**1 Denistone Road Eastwood
Ryde Hospital Redevelopment Concept and Stage 1 (SSD-36778089)**

City of Ryde Submission to RTS

Ryde Hospital Redevelopment:
Amended Concept Masterplan and Stage 1 Site Works

Submission Date: 7 February 2023

Figure 12 View 2: Denistone Road centre – proposed view

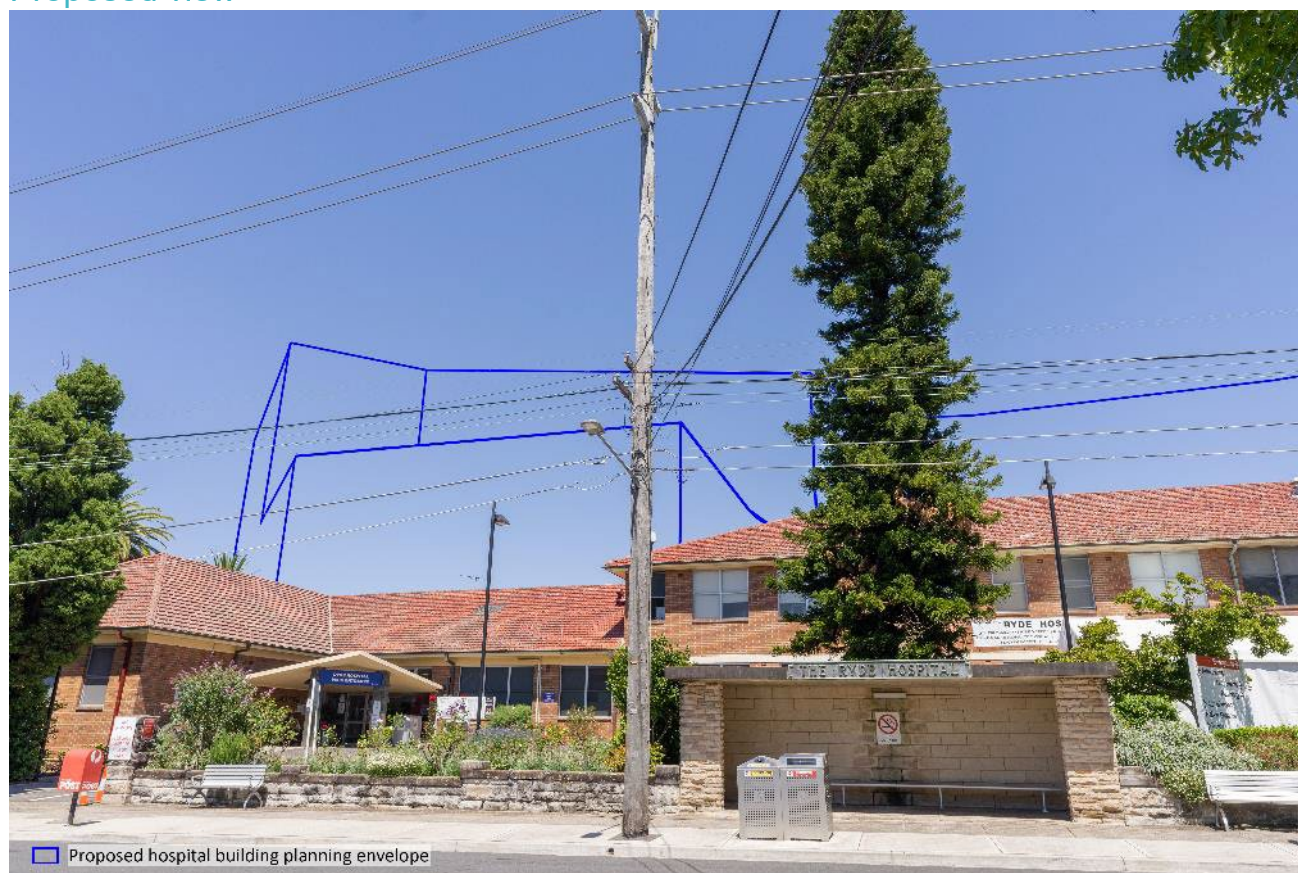
- The views included in the Visual Impact Assessment(VIA) report appear to be captured using a wide-angle lens, which will create excessive distortion to the image, causing objects at the centre of the image to appear smaller and more distant. For VIAs, a focal length of 35mm to 50mm are generally recommended for conducting view analysis as they most accurately represent the scale of objects perceived by human eyes. It is advised that the DPE requests all views in the VIA report be updated to ensure they can accurately represent the scale of development.

- The Applicant's response to submissions indicates that survey points are shown in each view, but they are not evident in the VIA report. The 'Appendix: Visual impact evidence' (CMS and Virtual Ideas) is also absent in the document. There is no information to assist the DPE assessment officers in verifying the accuracy of the photomontages.

WEST ELEVATION - RYEDALE ROAD  
scale 1: 1000

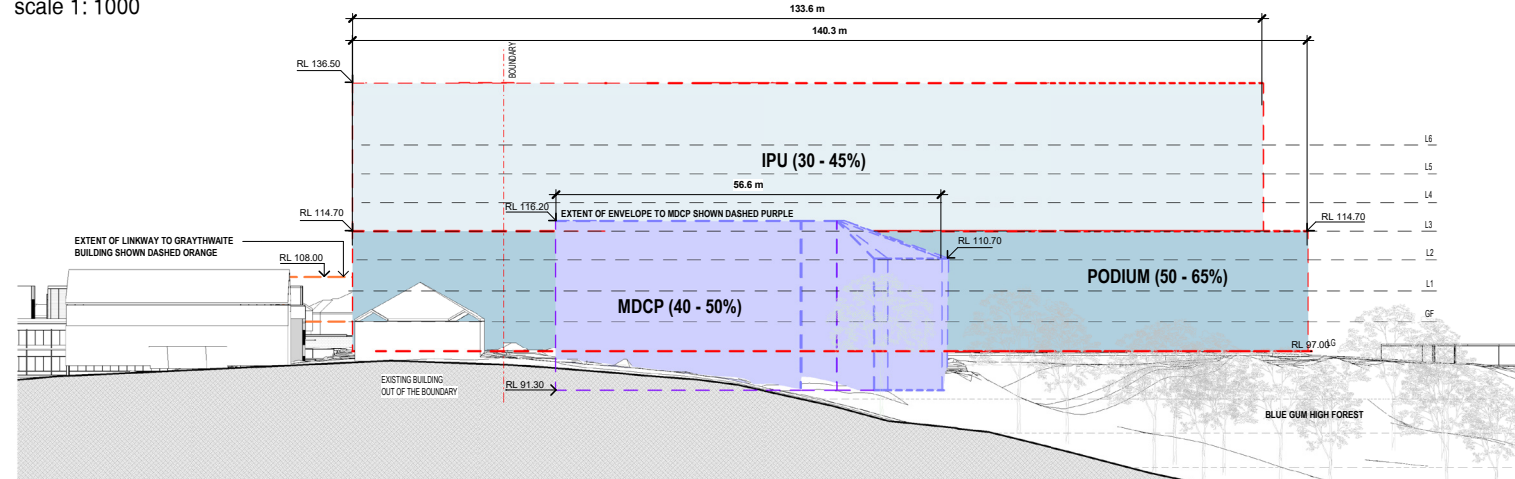
- ii. The formalised access location off Ryedale Road to the new multi-storey carpark will result in sight line issues due to the crest in Ryedale Road. Traffic control measures may be required at this access location. Further comment is sought from Council's Transport Department.

**EAST ELEVATION - DENISTONE ROAD**  
scale 1: 1000

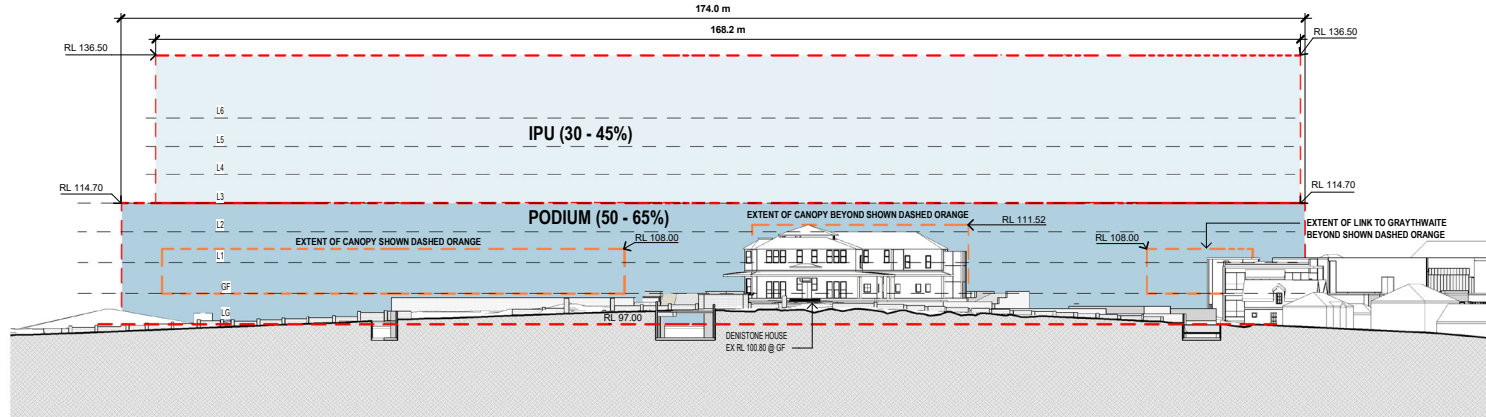
- Relocating the Multi-Deck Car Park(MDCP) building envelope from Ryedale Road to Denistone Road does not fundamentally address the issues regarding visual impact and street setbacks. While the visual impact on the public domain of Ryedale Road is reduced, the issue has been shifted to Denistone Road (see comments above regarding 'Public Domain Interface'). The MDCP building envelope is 17.5m high, equivalent to a 5-storey scale, directly opposite an R2 zone with an LEP height limit of 9.5m (or 2 storeys). The proposal should introduce a secondary setback along Denistone Road to provide a lower scale street wall and recess the upper storeys to reduce its visible bulk.

- The negative visual impact of the proposed at-grade car parking remains unresolved. Replacing existing one to two-storey hospital buildings with car parking along Denistone Road is a poor design outcome. The proposed car parking or vehicle access space will occupy over 60% of the site's frontage on Denistone Road (see proposed site access plan on page 44 of Architectural Design Report). Car parks (either at-grade or multi-storey) provide minimal activation and passive surveillance to the street and create large areas of hard paved surface. It will not only fail to enhance the existing streetscape but compromise public safety of the street, impact the visual quality of the street and limit the opportunities for deep soil landscaping and tree planting on the site.

- Undercroft car parking fronting public streets is not supported.
- The proposed 2m street setback from the Denistone Road frontage is inadequate. It will not allow for sufficient deep soil to support large canopy trees in the street setback zone. The proposed street setbacks must consider the context and respond to the existing streetscape character.

The majority of the existing dwelling houses on the eastern side of Denistone Road have street setbacks from 6m to 7m. The Ryde DCP 2014 requires a street setback of 6m in an R2 Low Density Residential Zone. Therefore, a minimum street setback of 6m with deep soil should be provided.
